RE: Eastdale Shopping Center 9450 Candelaria Rd. NE (H20D018)

COMMENT RESPONSE LETTER: TRAFFIC CIRCULATION LAYOUT 1ST ROUND

C200

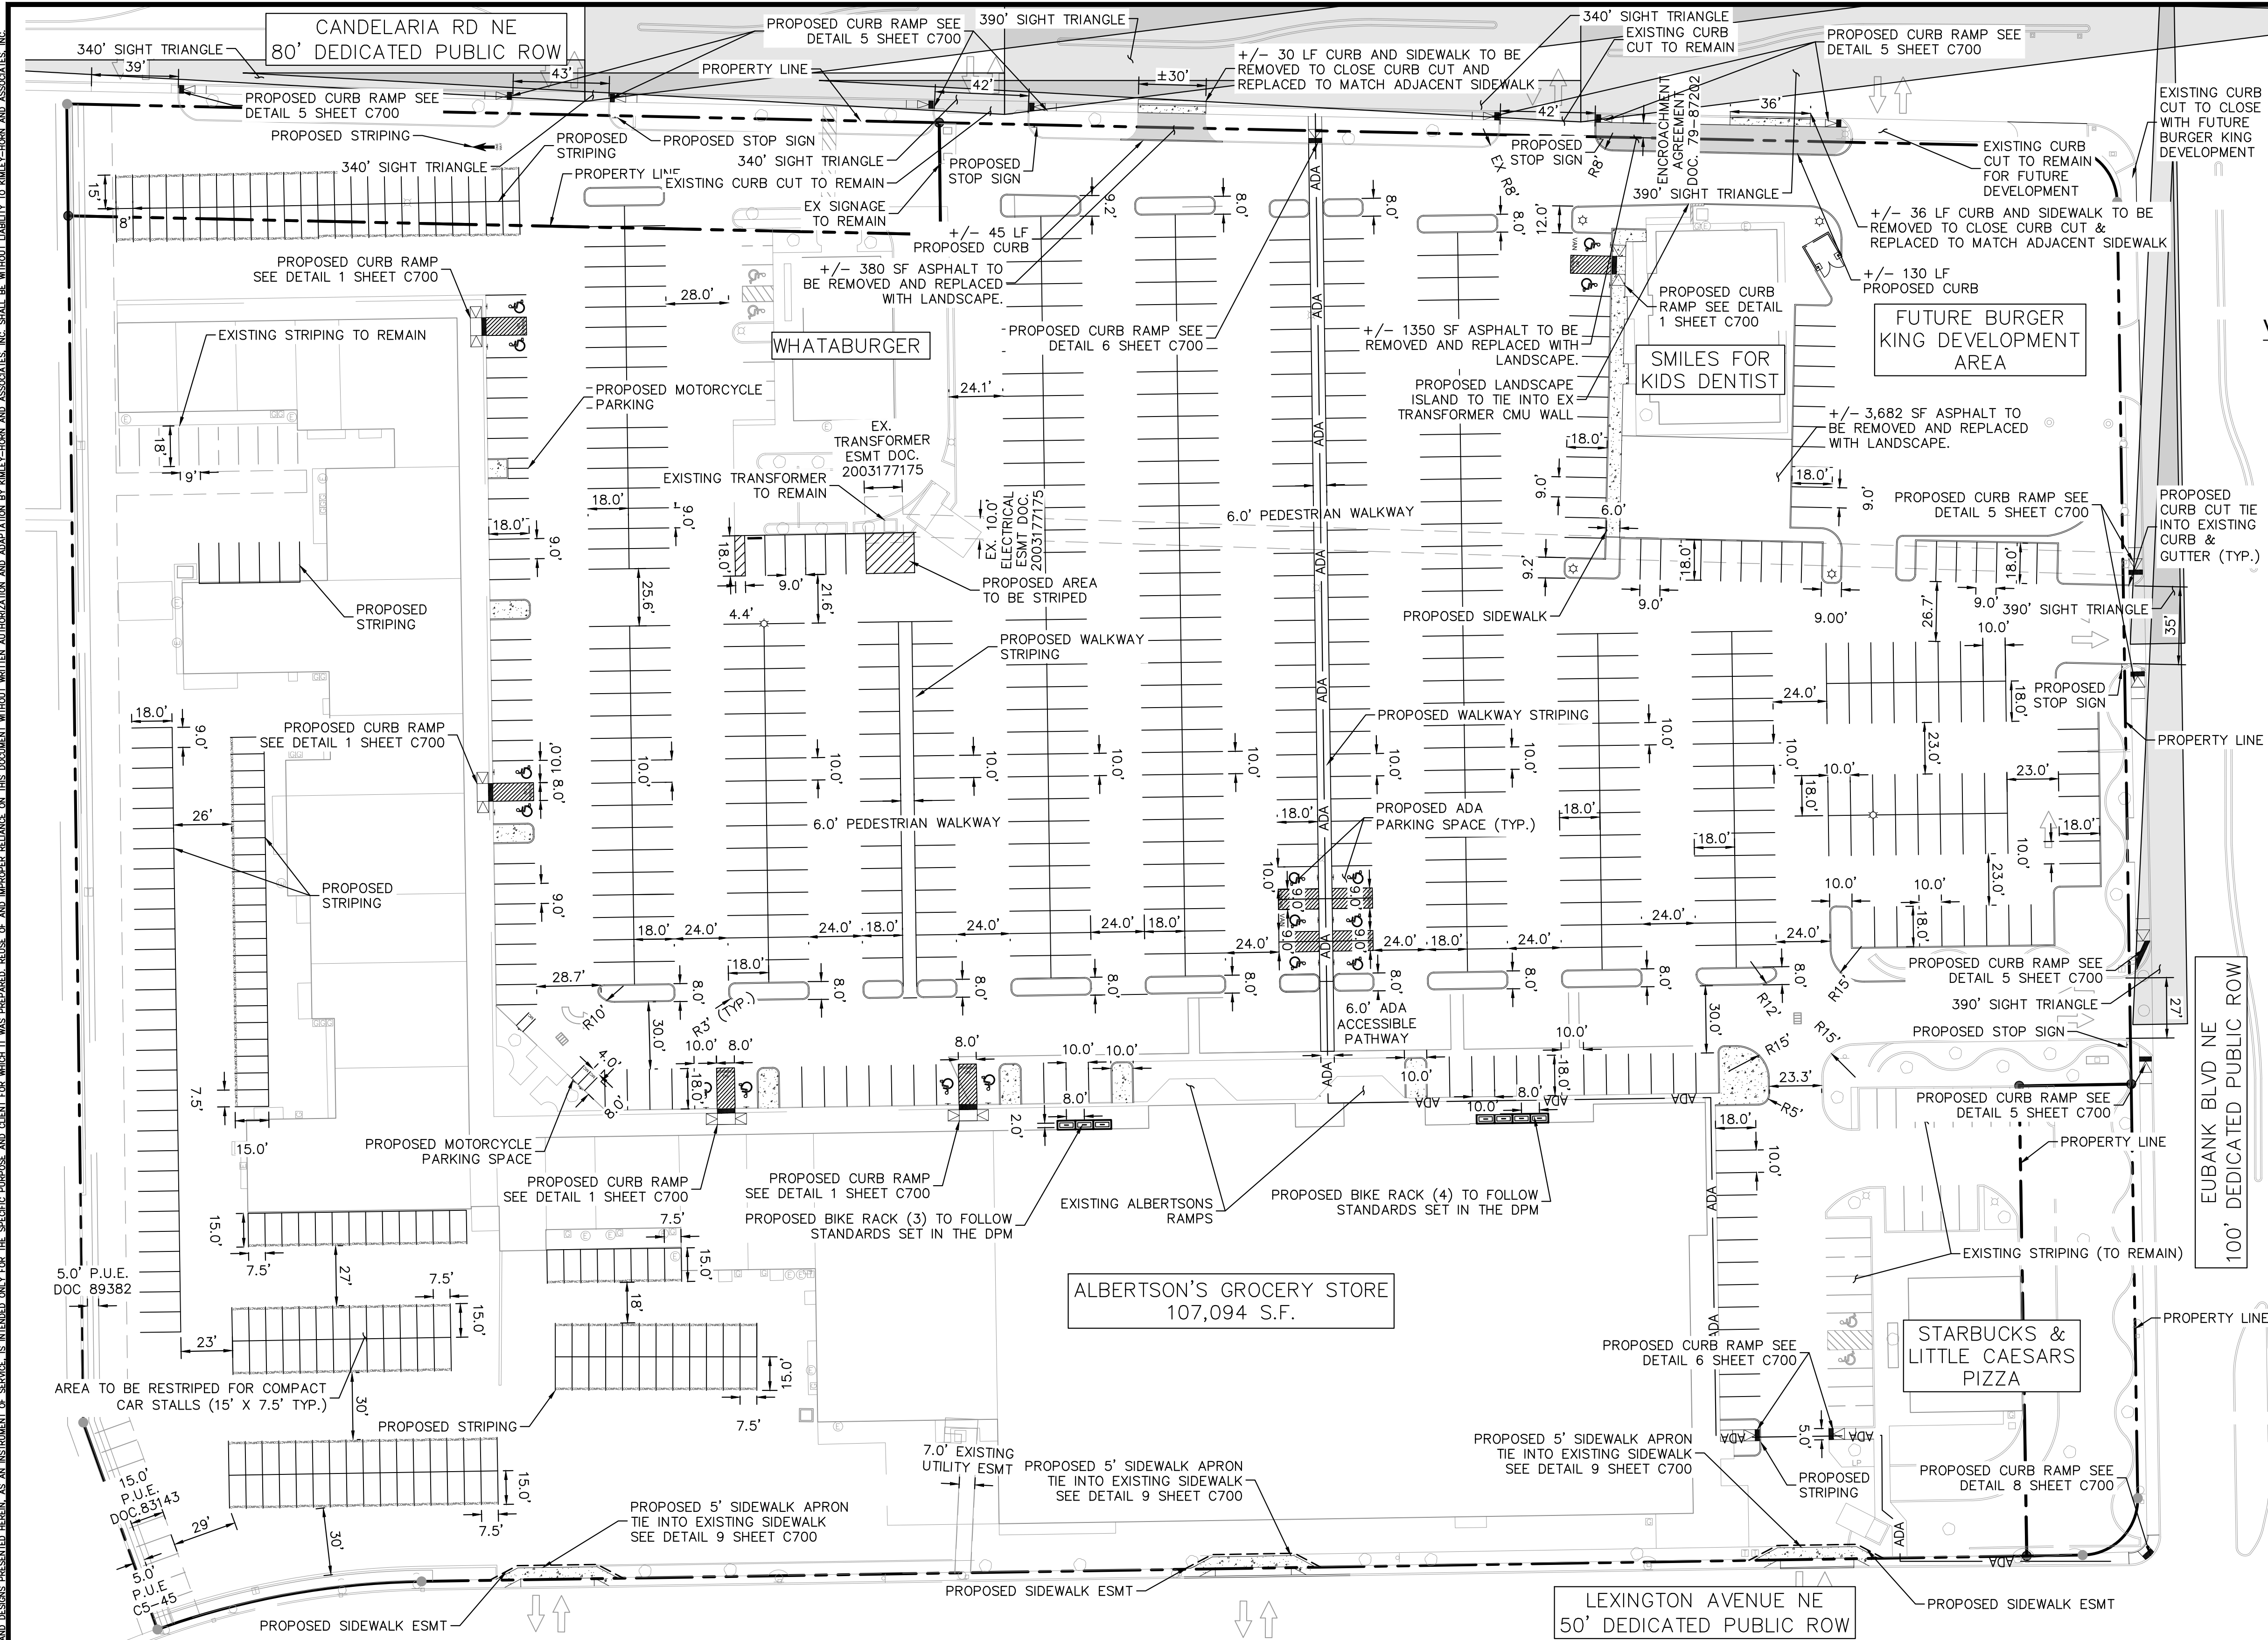
1. Please show a vicinity map on the site plan sheet showing the location of the development in relation to streets and well-known landmarks.
 - *Response: A vicinity map is shown on the site plan as specified.*

3. Identify all existing access easements and rights of way width dimensions.
 - *Response: All existing access easements and right of way width dimensions annotated on plans as specified.*

4. Please show on the site plan all site accesses width.
 - *Response: All site access widths shown.*
5. All site accesses must be updated to current ADA standard. Please provide site accesses design details.

12. Show all drive aisle widths. Some dimensions are not shown.
 - *Response: All drive aisle widths shown as specified.*
13. The minimum drive aisle dimensions are shown below.

16. Per the IDO, a 6 ft. wide ADA accessible pedestrian pathway is required from the public sidewalk to the building entrances. Please ensure that this pathway connection with the public sidewalk is clearly shown on the site plan, and provide details.

17. Per DPM, a 6 ft. wide ADA accessible pedestrian pathway is required from the ADA parking stall access aisles to the building entrances. Please clearly show this pathway and provide details.

- *Response: A 6-foot-wide ADA accessible pedestrian pathway is proposed to both Candelaria Rd NE and Lexington Ave NE. This pathway is delineated with a specified ADA accessible route line type, noted in the legend of the site plan. (NOTE THERE IS APORTION OF WALKWAY THAT IS ADJACENT TO BUILDING THAT IS LESS THAN 6' WIDE.)*

- *Response: A 6' wide ADA accessible pathway is provided from the stall access aisles and is delineated as specified.*
18. ADA accessible pedestrian pathway should not be placed behind parking space or adjacent to a vehicular way. Vehicle and pedestrian/wheel chair conflicts should be avoided as much as possible.

C700

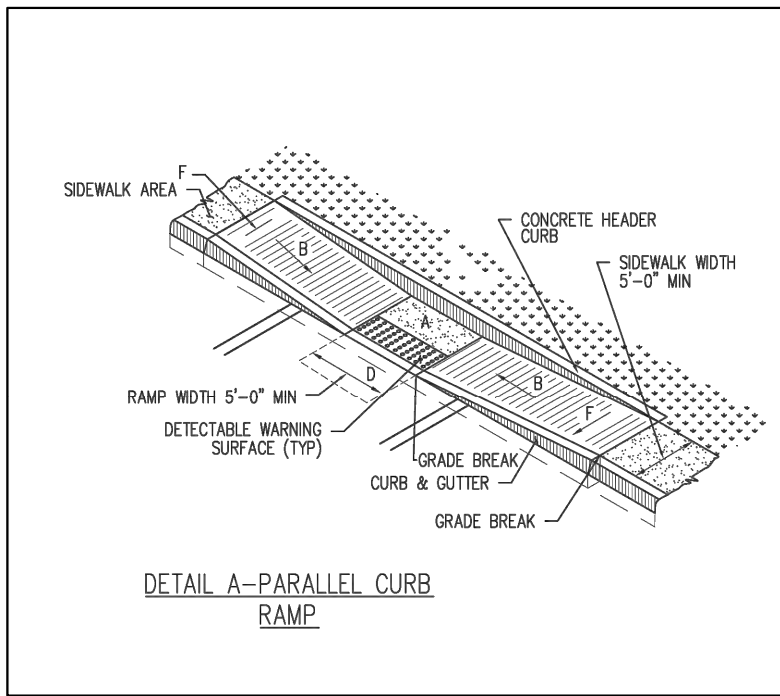
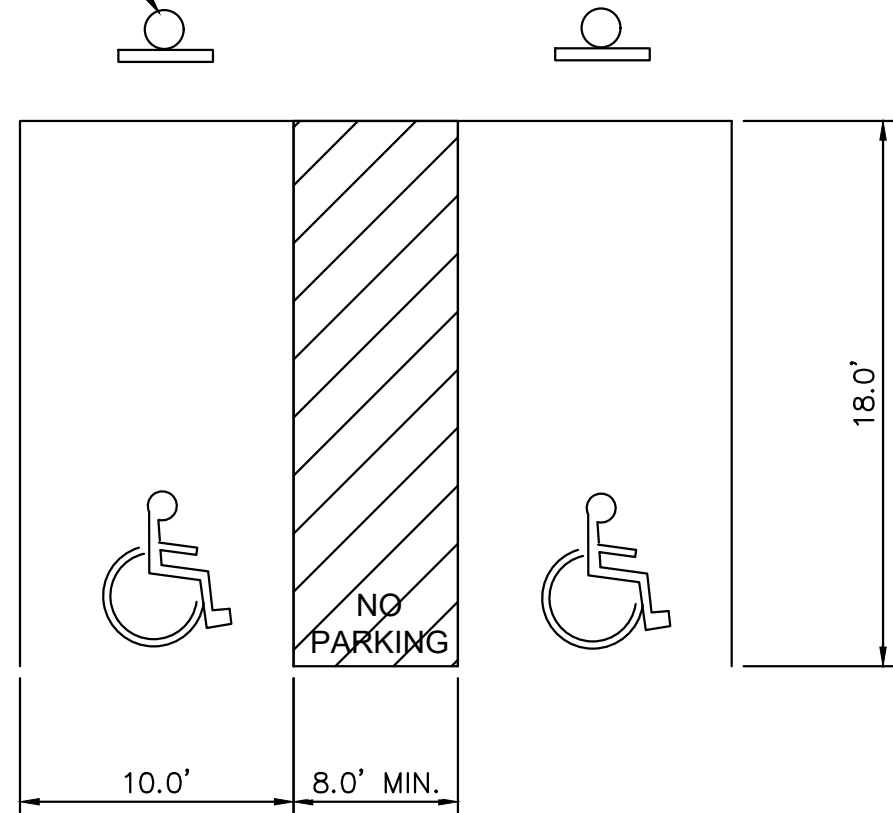
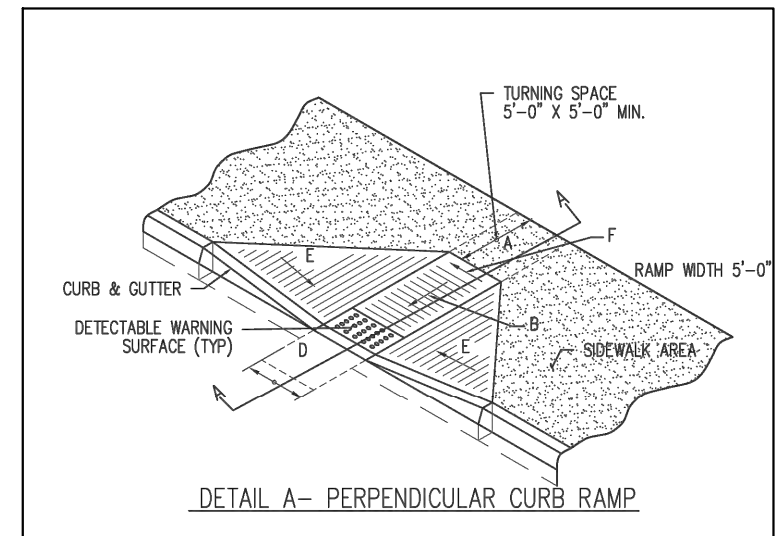
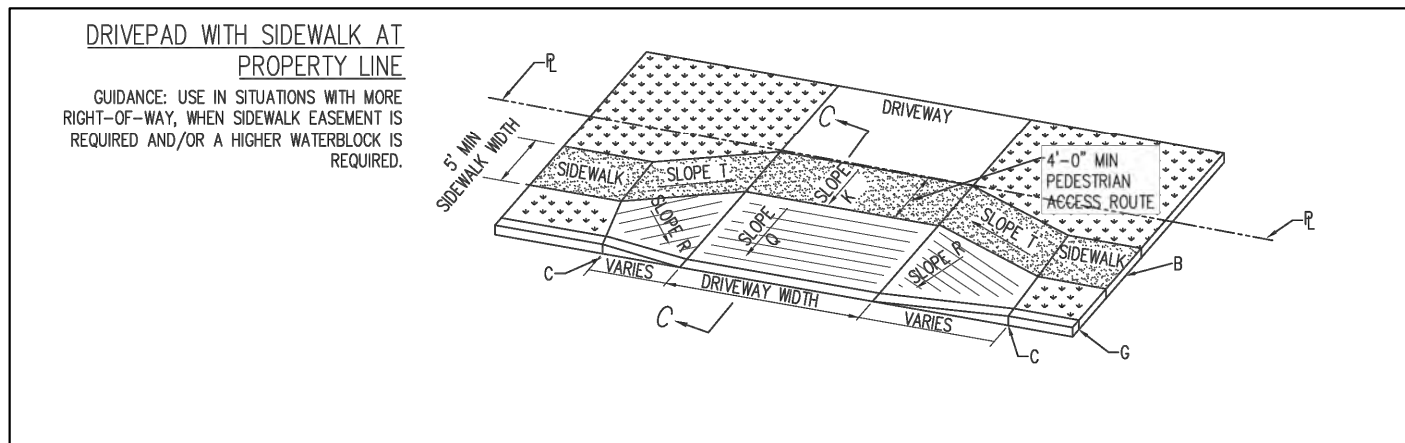
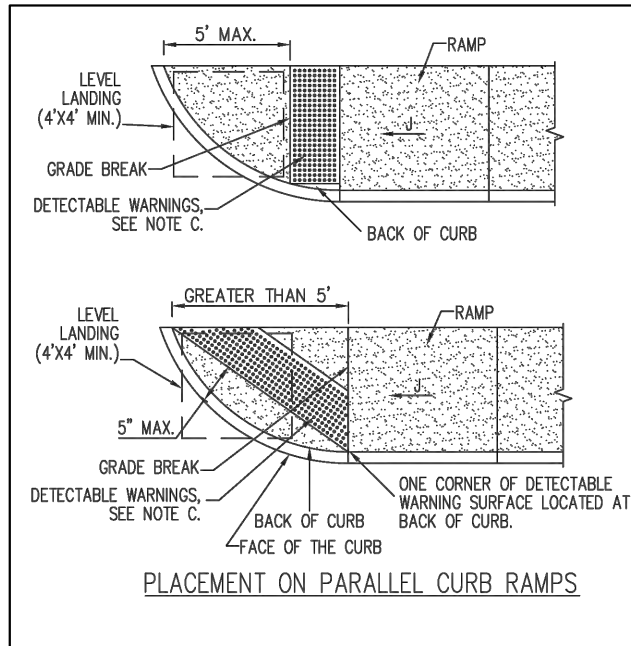
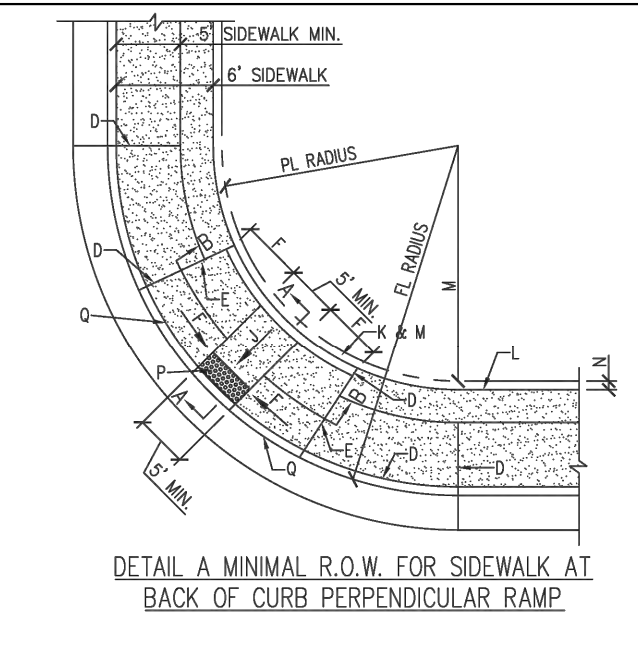
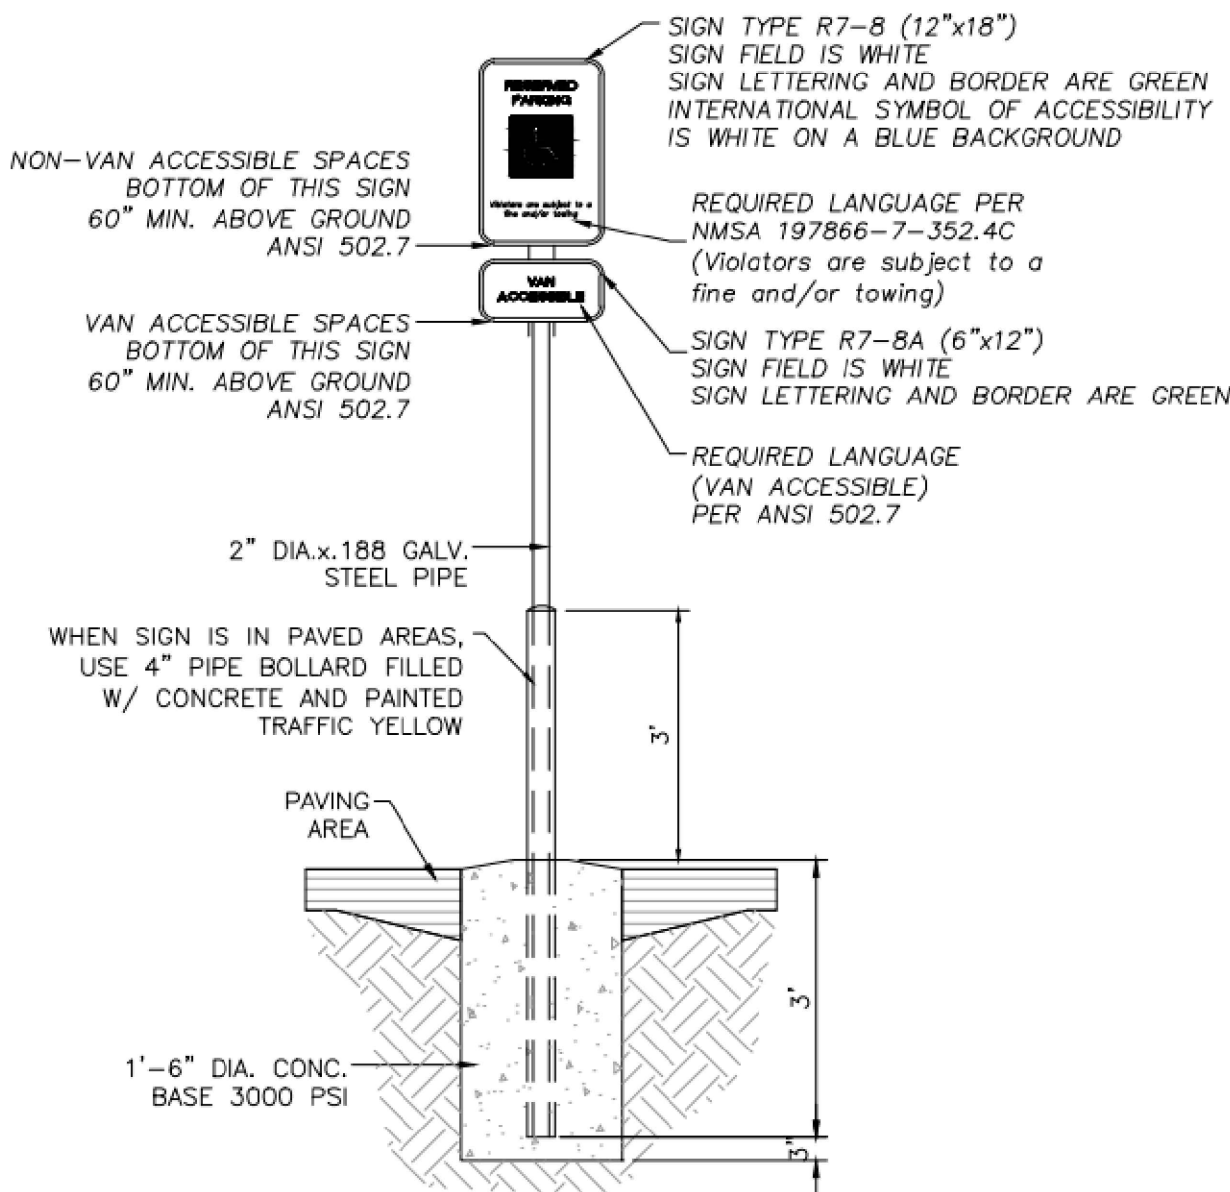
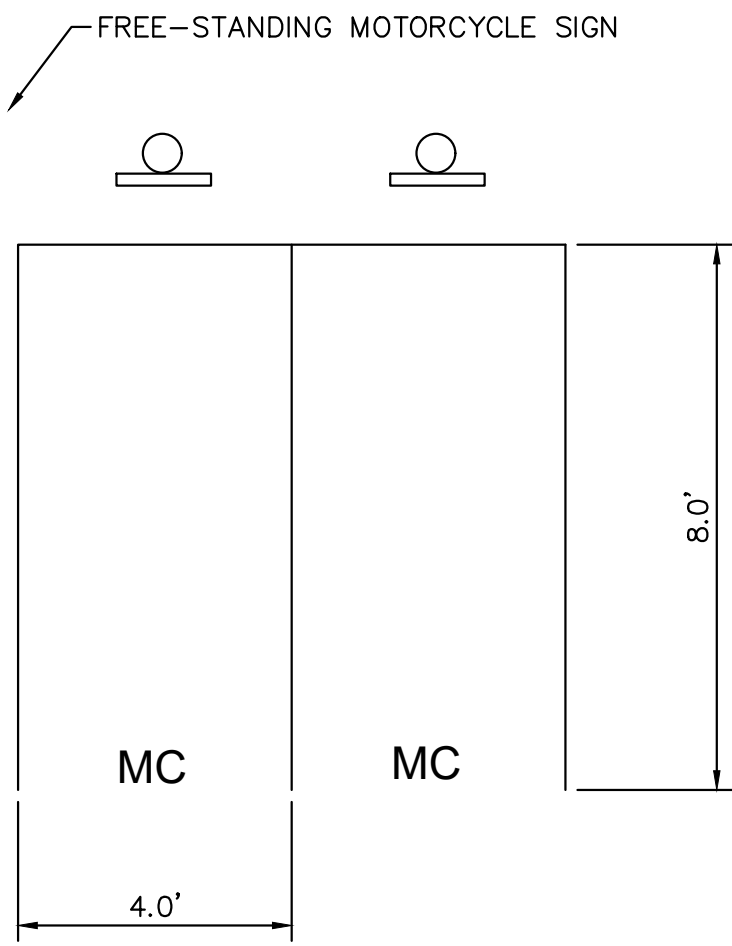
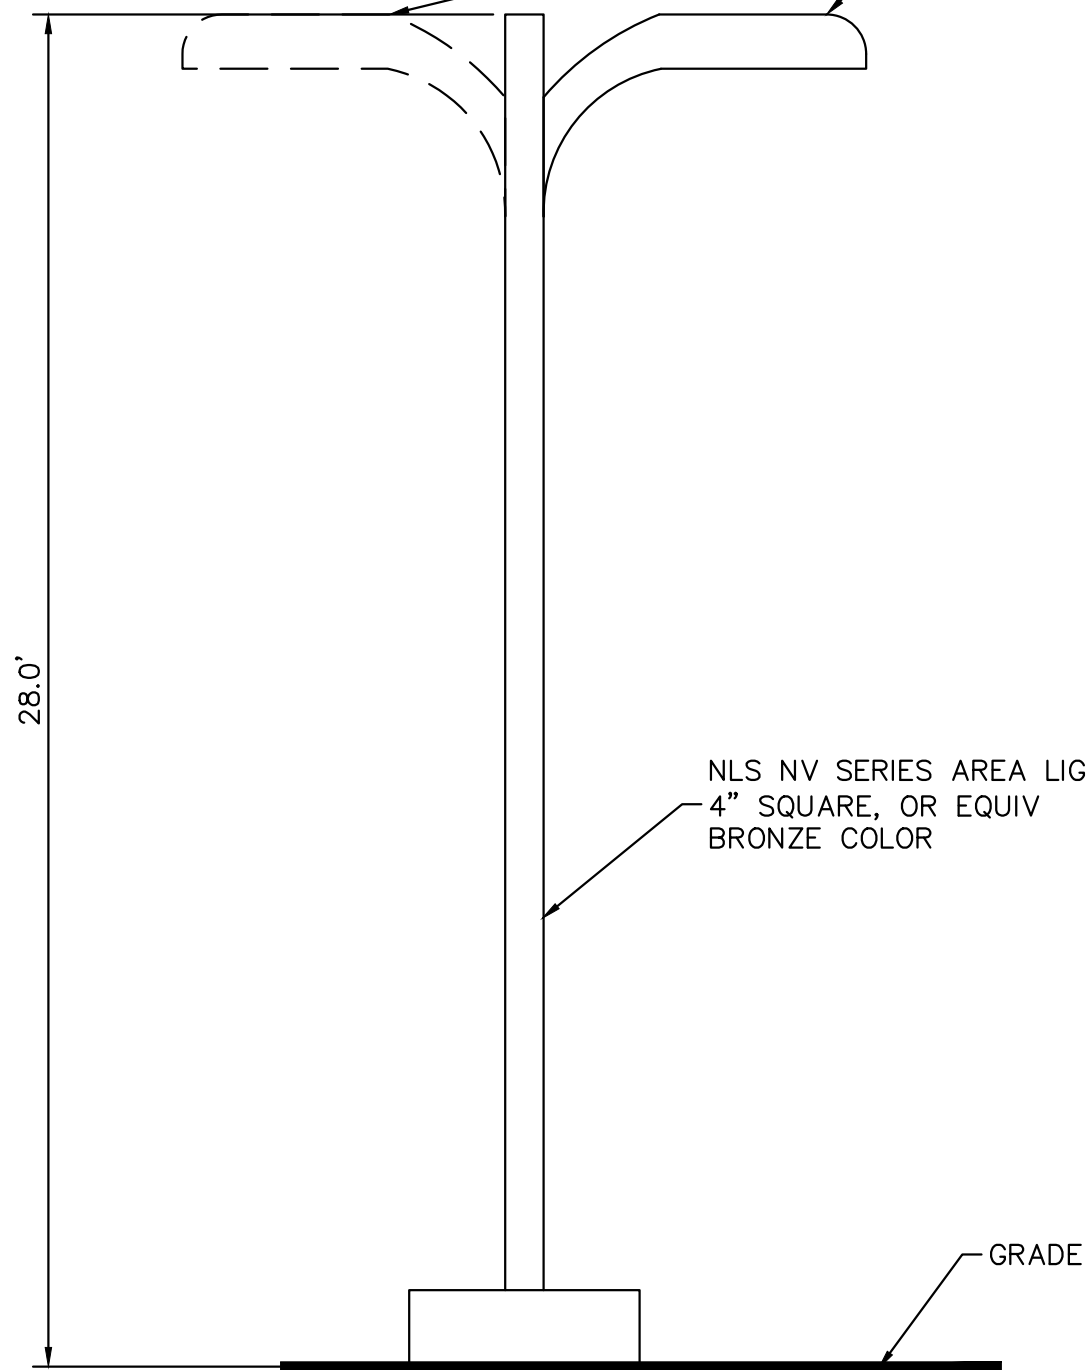
- *Response: All site accesses updated to current ADA standards with site access design details provided on Detail Sheet C700.*
6. ADA curb ramps at the site access off Eubank Blvd must be updated to current standards and have truncated domes installed.

8. The ADA access aisles shall have the words "NO PARKING" in capital letters, each of which shall be at least one foot high and at least two inches wide, placed at the rear of the parking space so as to be close to where an adjacent vehicle's rear tire would be placed. (66-1-4.1. B NMSA 1978).

- *Response: Free-standing sign proposed in each motorcycle space.*
10. The pavement marking "MC" should be shown in the opposite direction for motorcycles entering the parking space.

- *Response: All curb ramps at site access off Eubank Blvd must be updated to current standards and have truncated domes installed.*

- *Response: ADA access aisles now include the words "NO PARKING" as specified on each stall.*
9. Motorcycle parking spaces shall be designated by its own conspicuously posted upright sign, either free-standing or wall mounted per the zoning code.

- *Response: MC shown on the pavement spaces.*
11. Please see attached Bike rack requirement.
 - *Response: Bike rack requirements and dimensions followed as specified.*
